From: Andrew Wood
Sent: 19 June 2017 11:42
To: [REDACTED]
Subject: RE: FG 198/16/PL - VERY URGENT

From: sally henderson [REDACTED]
Sent: 14 June 2017 22:58
To: Neil Crowther
Subject: Re: COMPLAINT Ref FG 198/16/PL

In the meantime, i have read the officers report on this application and would like to highlight errors and inconsistencies as follows -

SIDE ELEVATION

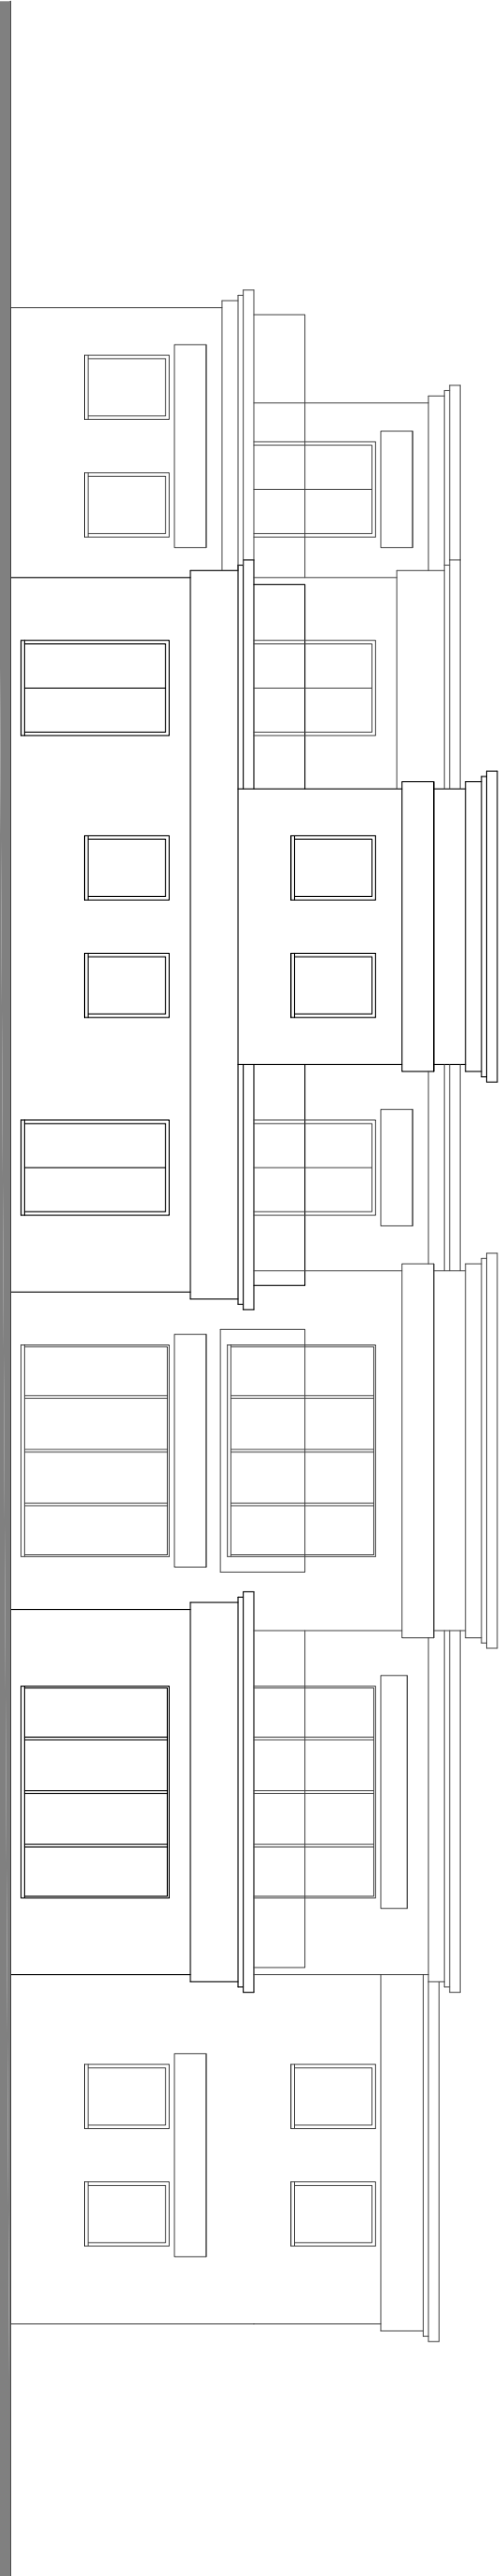
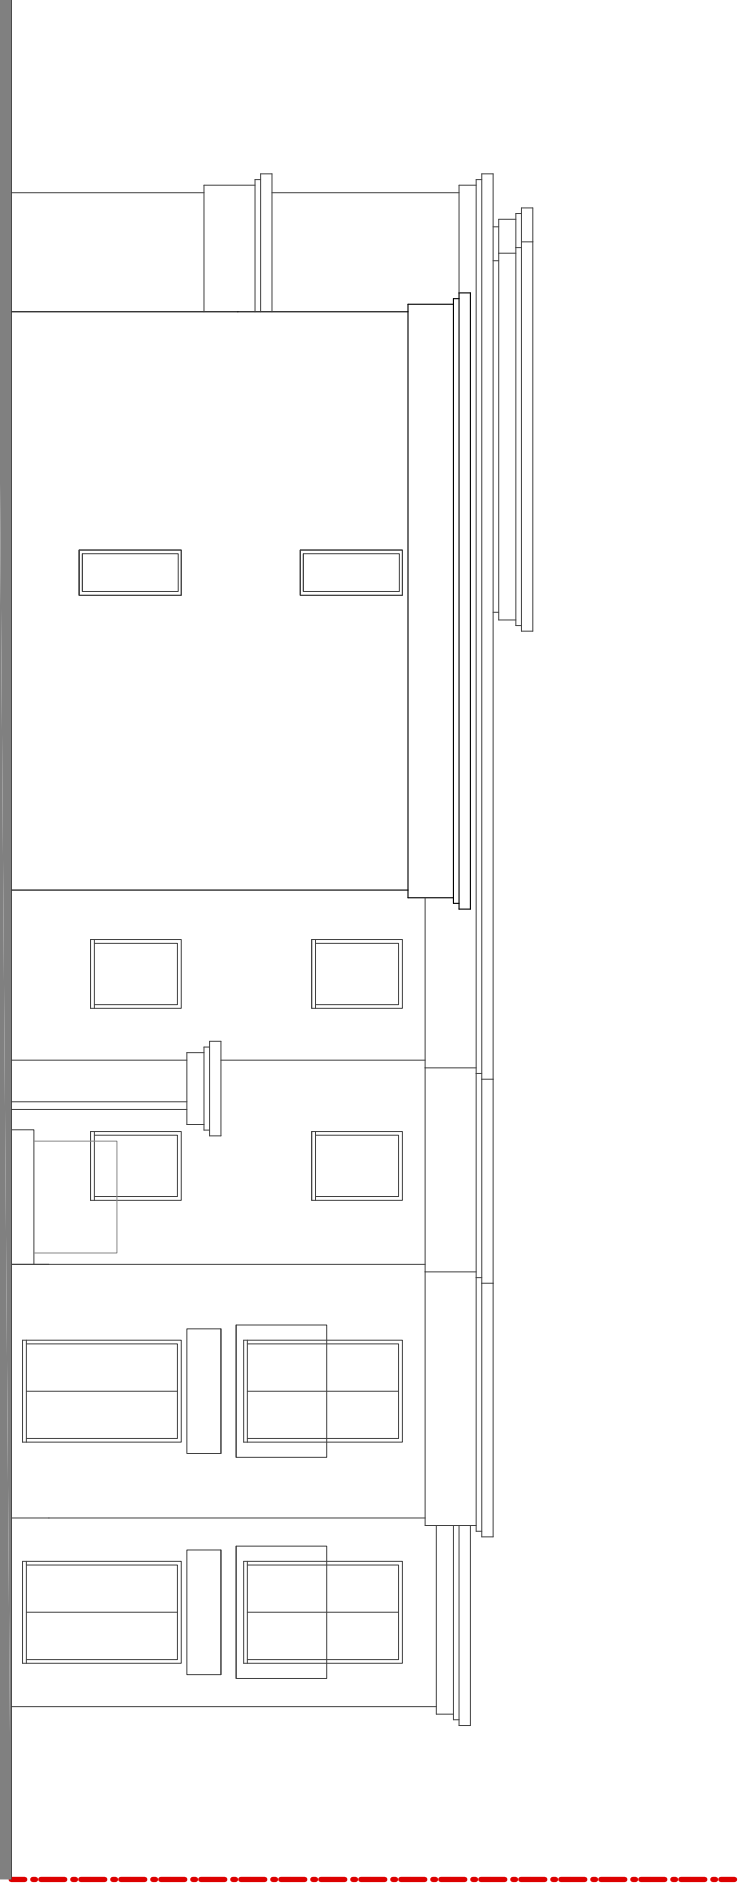
3. **Deletion of window** - the applicant’s email of 24/5/17 to Andrew Wood, published on 26/5/17 states that “I confirm that the obscure glazed window shown to the kitchen / living / dining at first floor on the western boundary elevation will be removed”. However this window is still shown on the most recent drawing - revision G - so there is no accurate drawing that the public can see and that planning consent can be given to.

4. **Overlooking** - p.33 states “All windows in the northern section on this West facing elevation would be obscure glazed with the exception of 2 bedroom windows at ground and first floor level at the northern most end of the building which would be in excess of 20 metres away from the closest rear window at 3 Sea Drive and at a 90 degree angle. This impact on residential amenity of relationship of the built form and windows of the new development to the rear windows and rear amenity areas of 3 Sea Drive is considered acceptable.

This raises 2 inconsistencies -

a.) I have attached a scan of the applicant's site plan revision G, on which i have marked the sight lines from the 2 clear bedroom windows - bearing in mind that overlooking will be able to occur from ground and first floor due to the raised floor levels meaning windows are higher than fence height. It's clear that these windows can see into the habitable rooms of our home as well as overlook the entirety of our rear garden, even including our courtyard area which is enclosed on 3 sides and where our private hot tub is located.

b.) Given that the report states that all windows on the West facing elevation will be obscure glazed bar the bedroom windows discussed above, why does proposed condition 14 only state that all first floor hallway, bathroom and en-suite windows at first floor level in the West and North elevations shall be obscure ? Why are the ground floor windows not included in this condition ? Why, also is the ground floor kitchen / living / dining window and the ground and first floor side windows to the master bedrooms not included in this condition ?

STREET SCENE SEA DRIVE

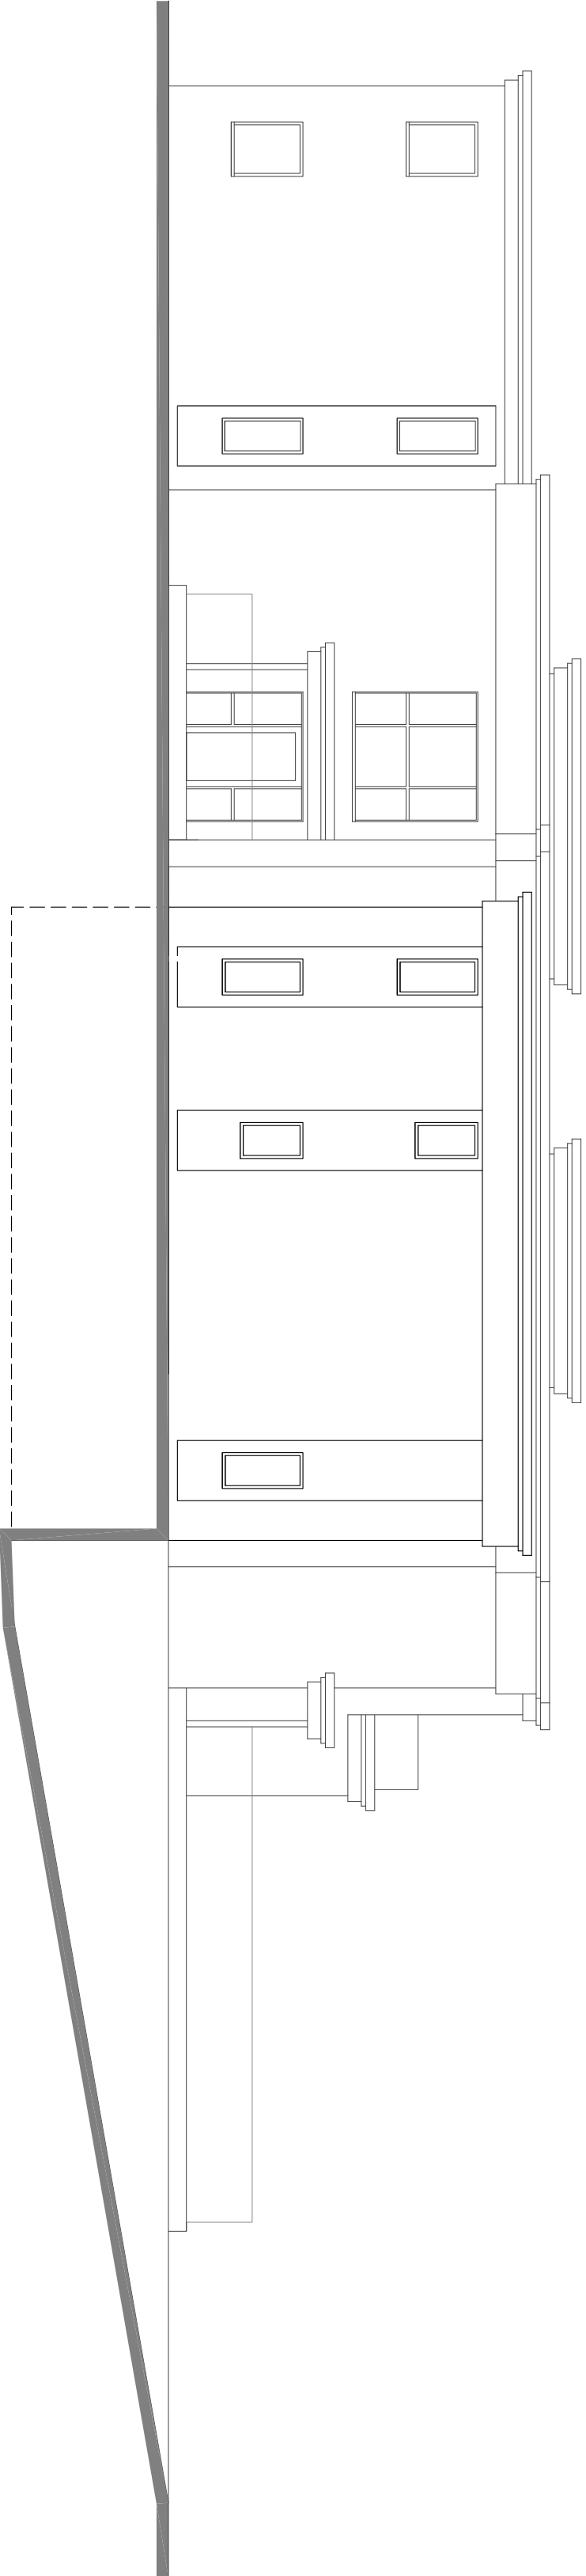
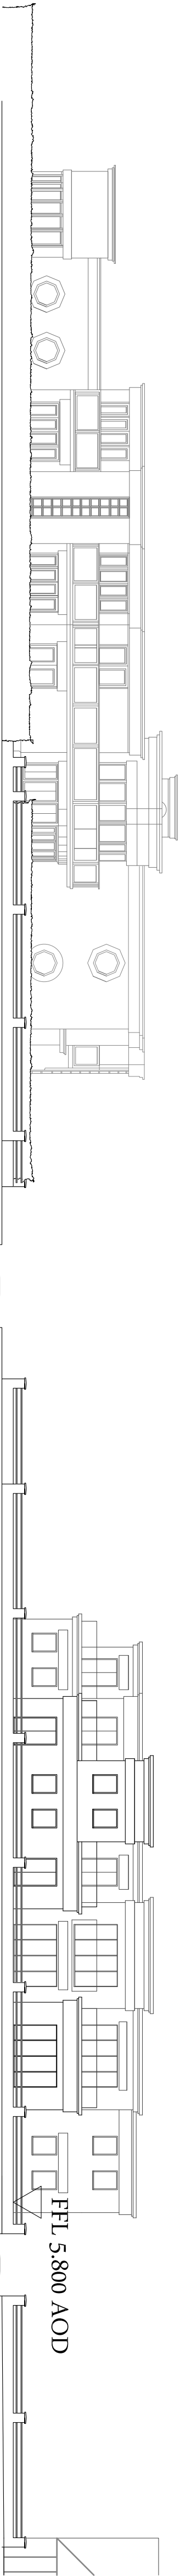
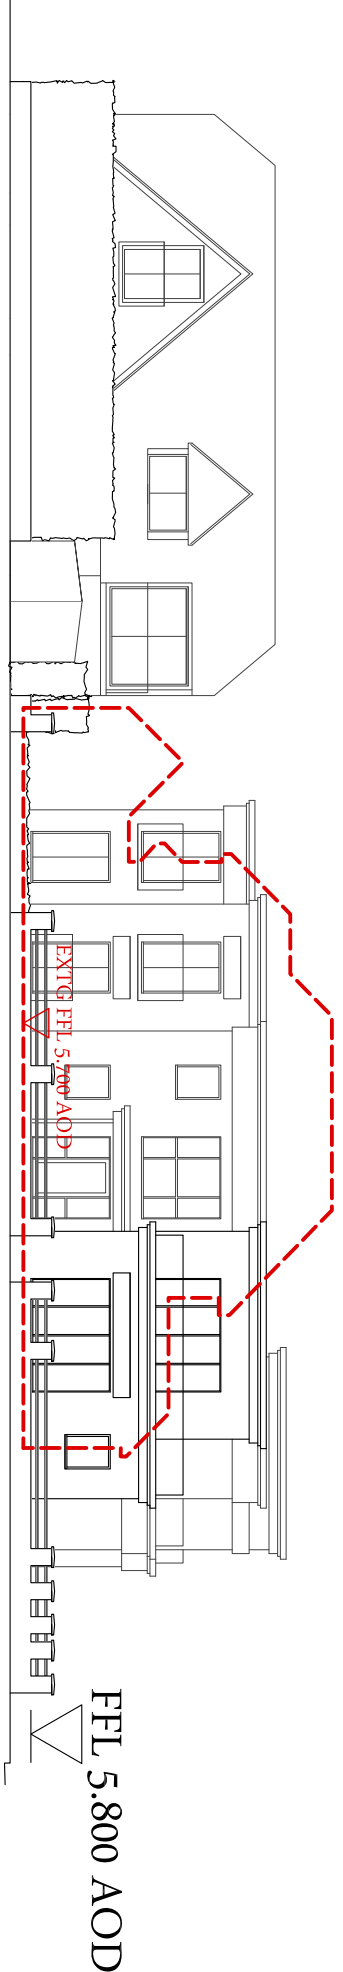
1. **Height of the proposed block of flats** - p 32 of the DCC agenda states that “the development would have a 6.4m maximum height on the front elevation on Sea Drive”. Andrew Woods stated in an email to my neighbour’s son, Jon Gann on 25/4/17 at 10.42, “The substitute elevation plan ‘proposed elevation and street scenes’ drawing no 16/046 PL005 Rev F dated March 2017....does indicate that the height of the building above the car park entrance has risen by 30cm from 6.3metres to 6.6metres.” This email was pasted into my formal complaint text. Should you be in any doubt i can forward it to you again.

What height is it ? Which statement is correct ? This is a hugely important factor in assessing the overbearing impact of the proposal and it simply is totally unacceptable to have these inconsistencies.

2. **Level of Windows** - p.33 states that “the level of the windows shown on street elevations matches that of 3 Sea Drive and would provide an acceptable relationship between the windows and floor levels of the neighbouring property”. It is very clearly shown on the applicant’s most recent street scene drawing 16/046 PL005 Revision G that the level of windows on the proposed flat block are significantly higher than those in our property. The finished floor level is shown as 5.8m AOD, this fact in itself makes it very clear that the windows will of course be correspondingly higher and the drawings confirm that indeed they are.

This is crucial to the extent of overlooking and loss of privacy and the facts have been stated incorrectly in the report which means the assumptions and conclusions are also incorrect - what will be done to rectify this mammoth mistake ?
